WEST SUSSEX COUNTY COUNCIL CONSULTATION

TO:	Arun District Council FAO: Stuart Corbey
FROM:	WSCC - Highways Authority
DATE:	21 March 2019
LOCATION:	209 Pagham Road Pagham PO21 3QD
SUBJECT:	P/23/19/PL Change of use of only ground floor betting shop (Sui Generis) to D1 (D1 Non-residential institutions) with alterations & demolition of rear single storey extension. This application may affect the setting of listed buildings.
DATE OF SITE VISIT:	N/A
RECOMMENDATION:	Advice
S106 CONTRIBUTION TOTAL:	N/A

PROJECT: Proposed Change of use with alterations at: Crown Racing, 209 Pagham Road, Pagham PO21 3QD.
DRWG TITLE: PLANNING: As Proposed Plans.
CLIENT: Mr & Mrs S. Markham

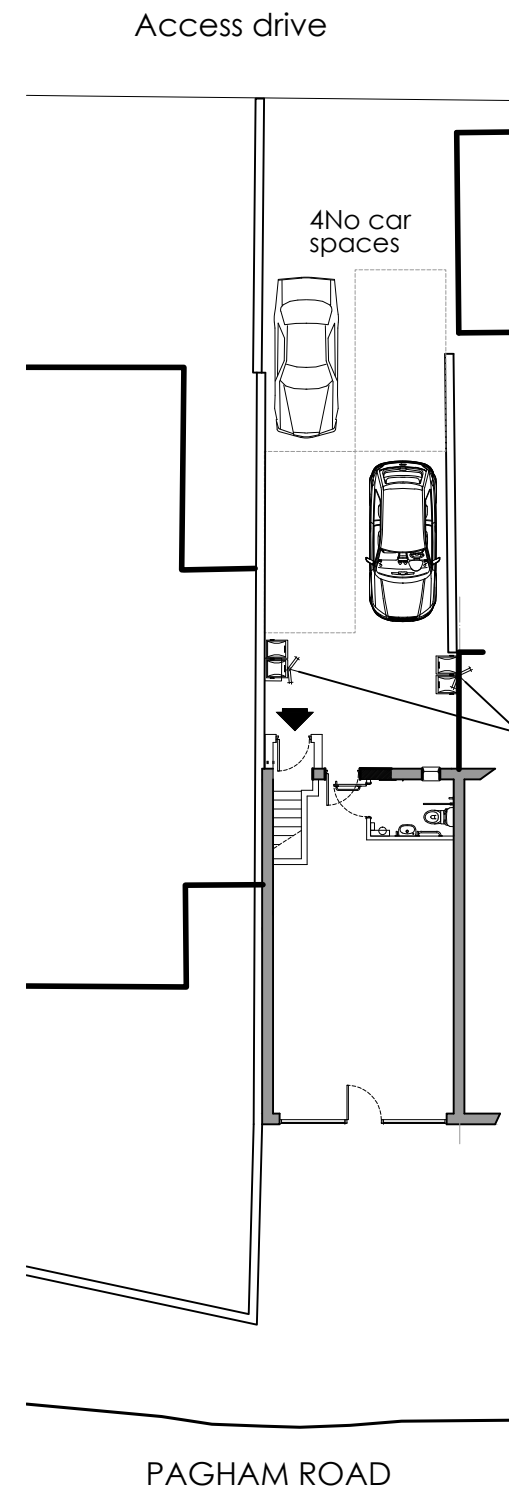
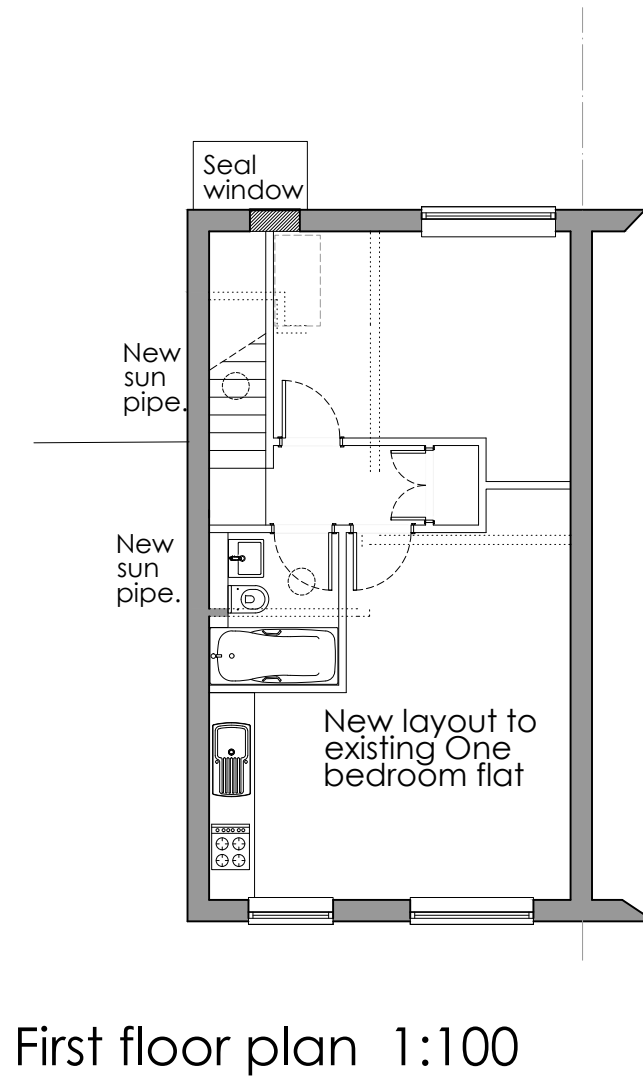
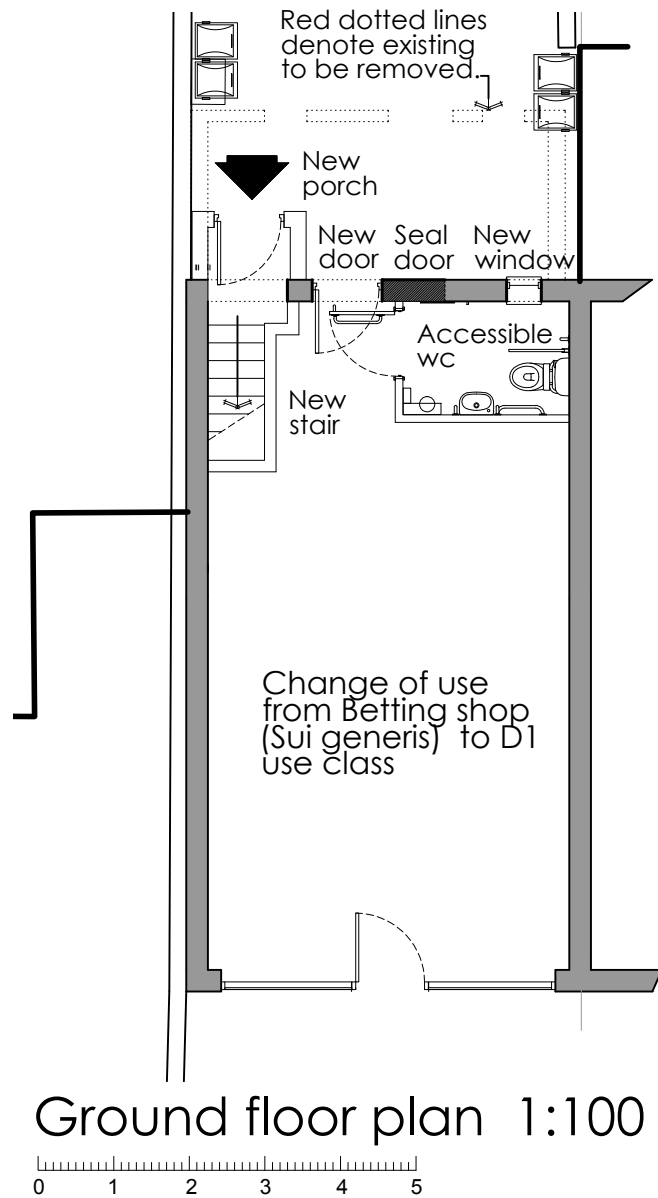
The proposed plans indicate that currently there are four parking spaces to the rear of the site which will be retained for the proposed use. It is unclear whether any of these are allocated to the existing residential use on the first floor of the site. The application form indicates that two full time staff will be employed for the proposed D1 use therefore this parking provision is anticipated to be sufficient for the proposed use. The site is located within metres of bus stops and other local shops and services, there is some unrestricted parking in the surrounding vicinity of the site, as such, the LHA anticipate that the level of traffic generated by the proposed D1 use would be of a similar nature to the existing use.
